Agency Review Comments

Project Name
North Bay at Lake Woodmoor Final Plat (2025)

File Number
SF263

FINAL PLAT  
NORTH BAY AT LAKE WOODMOOR

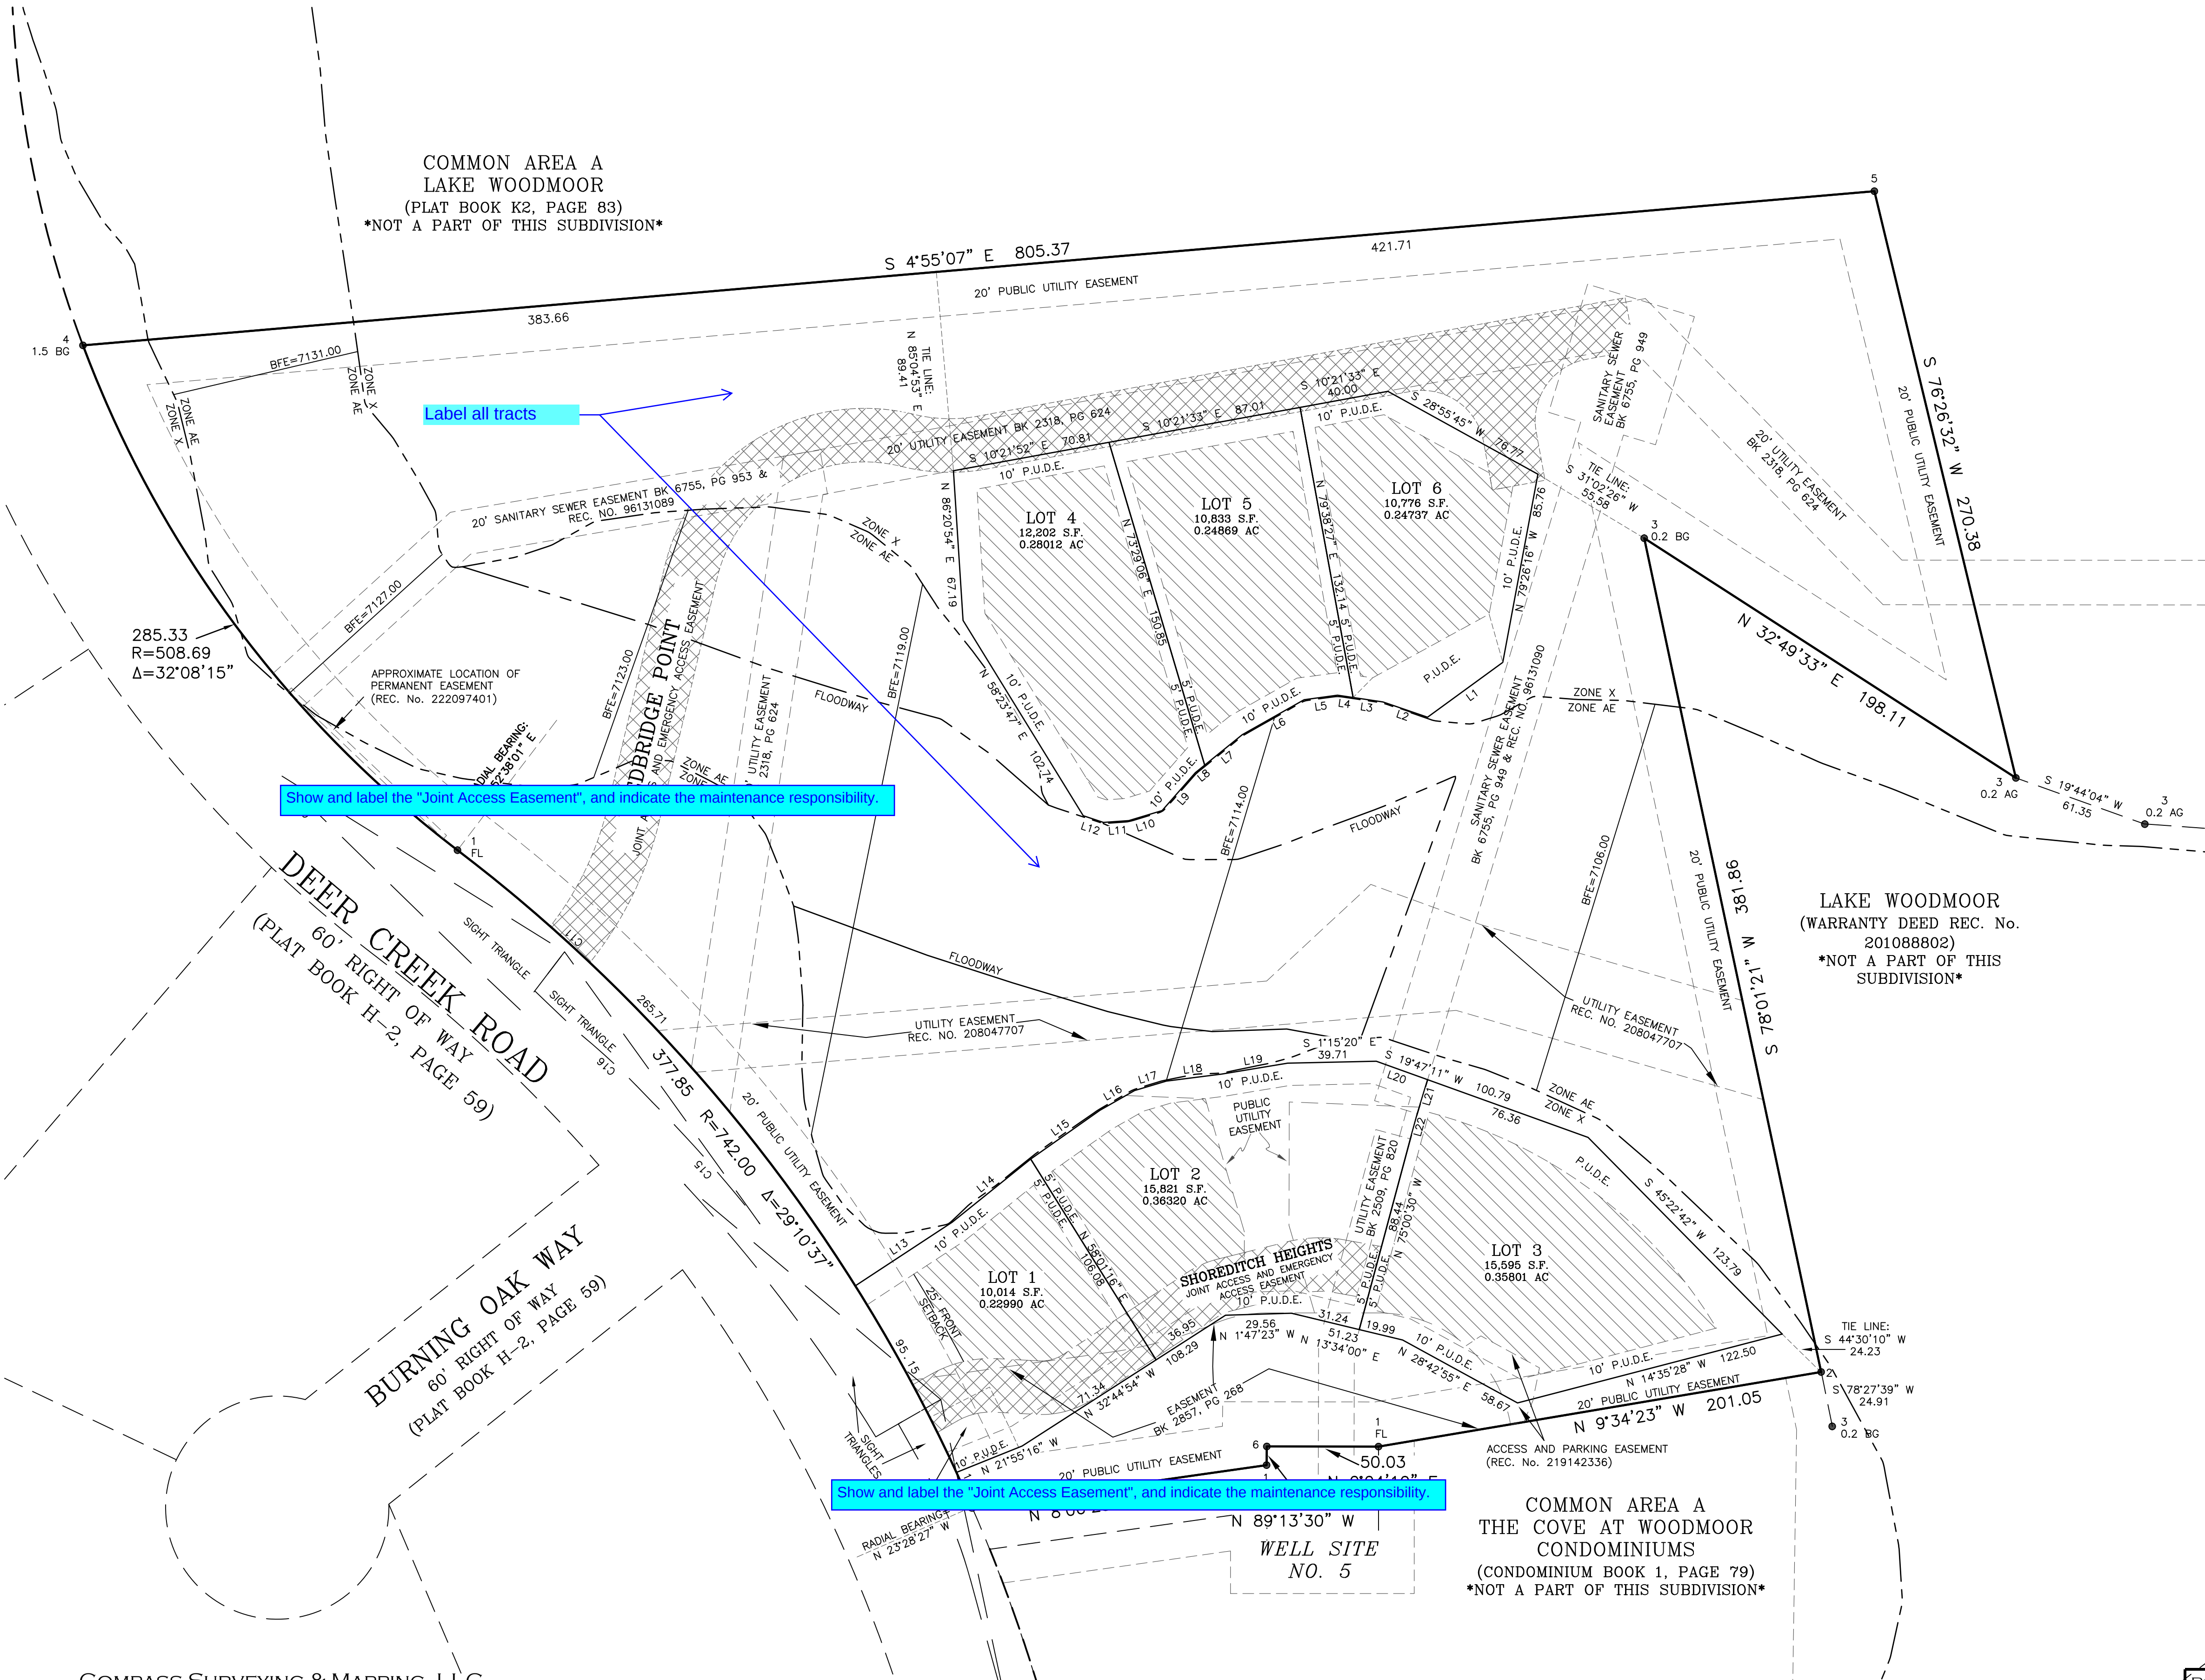
Agency	Review #	Comment	Date
Road Impact Fee Administrator	1	victoriachavez@elpasoco.com Please change the name of the document listed as "Road Impact Fee Credit Agreement." This is actually a "Road Impact Fee Acknowledgement Form." The credit agreement is a different document. Thank you for updating the form name. No further comments at this time.	2/18/2026 8:57:35 AM
RBD Floodplain	1	show floodplain extents and BFE lines on plat. seal and sign No rise certification form	2/17/2026 11:04:03 AM

Added, will seal and sign no rise certification with following submittal assuming no major comments remain.
